Application for a non-material amendment following a grant of planning permission.

Conversion of roof space to form living accommodation with Juliet balcony, rear facing dormer window and gable to side wall and roof lights.

We wish to tile hang the gable end to existing eaves height, instead of applying render as shown on the original application.

drawing no.:
COB/17 / 877/ 51

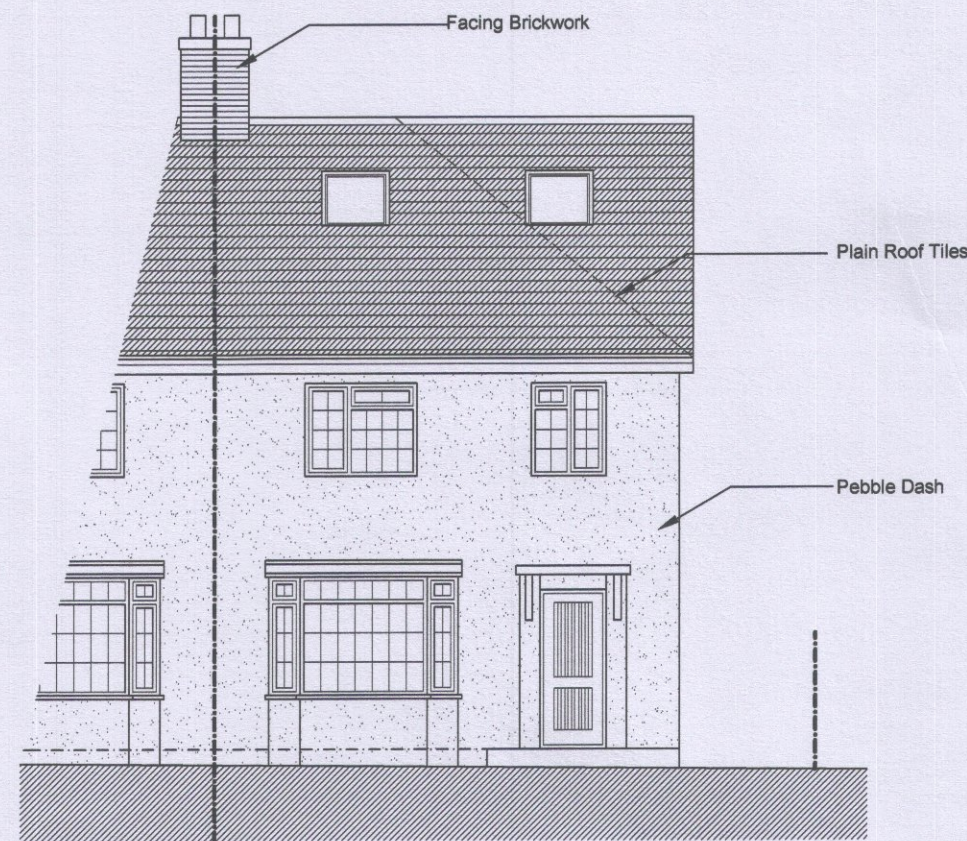
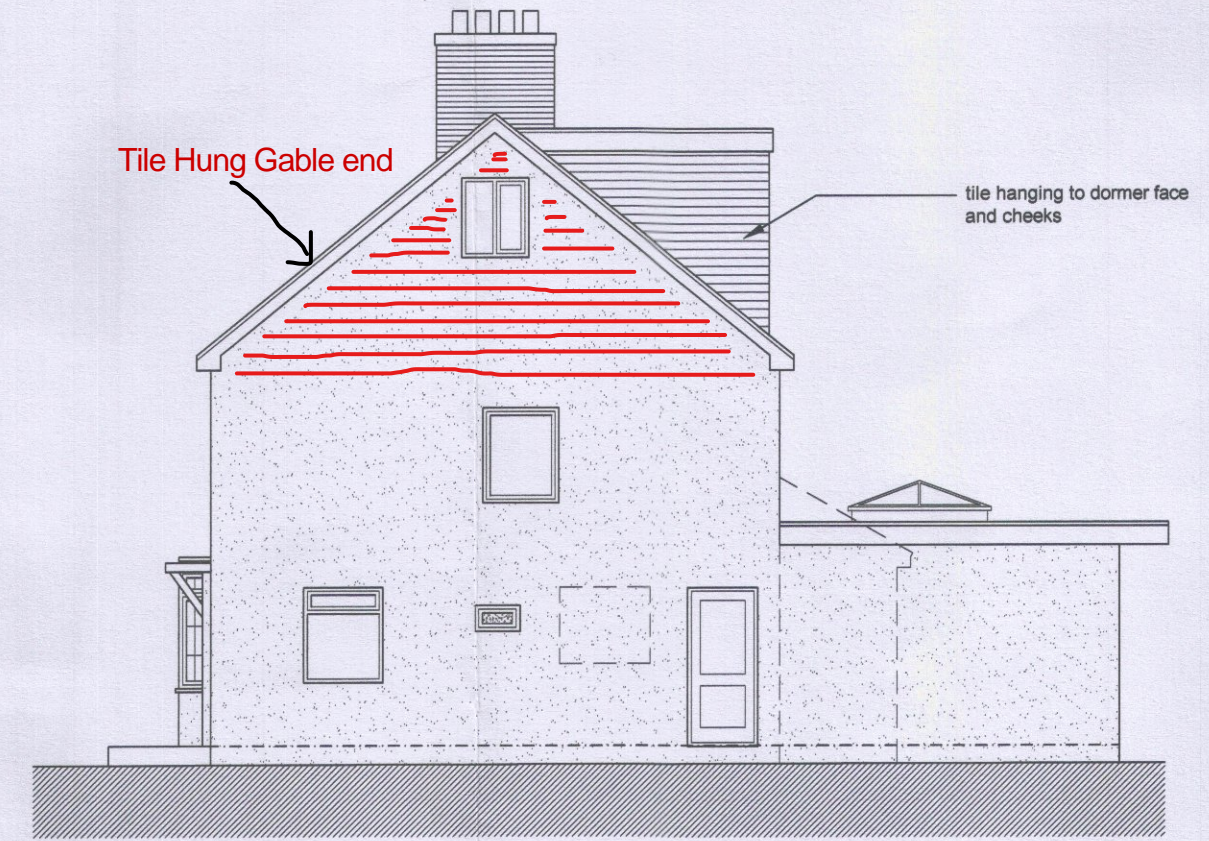
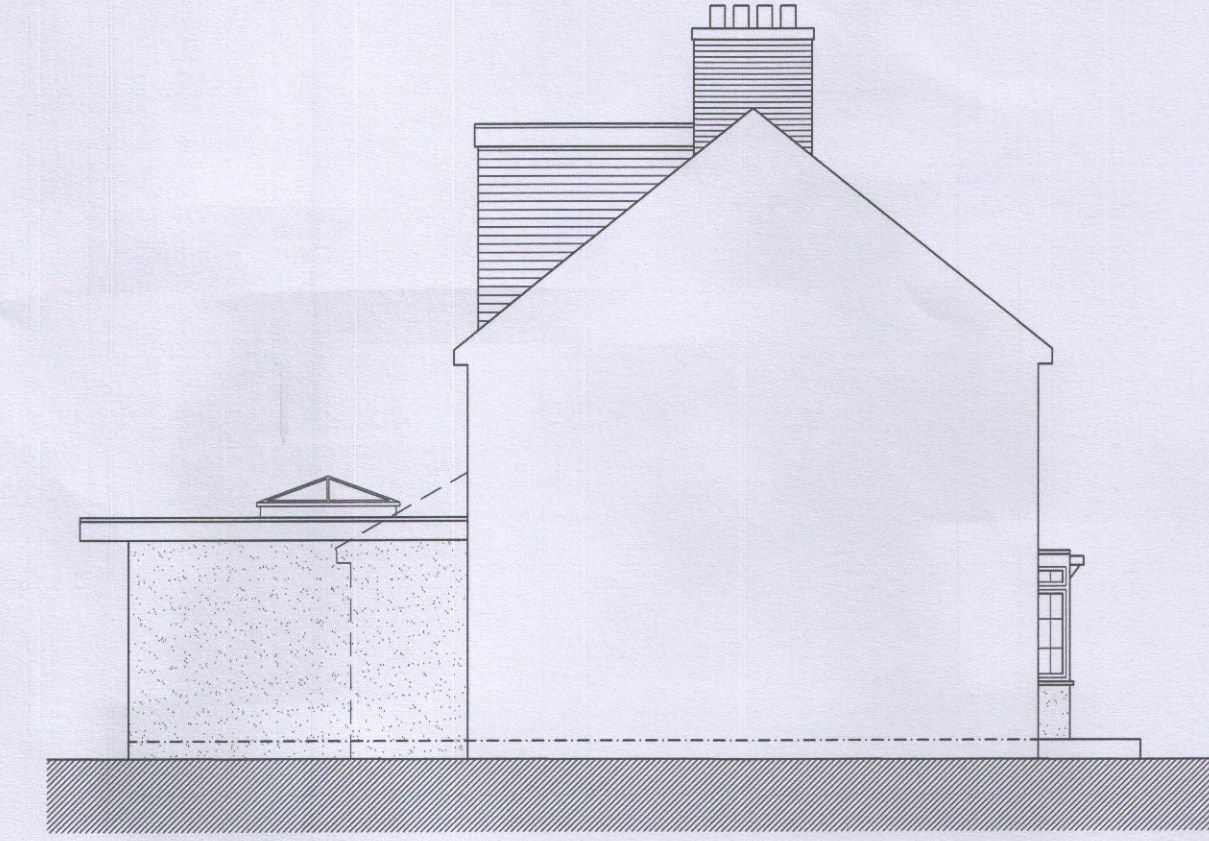
Builder has advised that render will be hard to maintain at this height and will become discoloured due to the lack of sunlight falling on the gable end area. Tile hung gable ends are also present in our row of houses so this will be in keeping with the local environment.
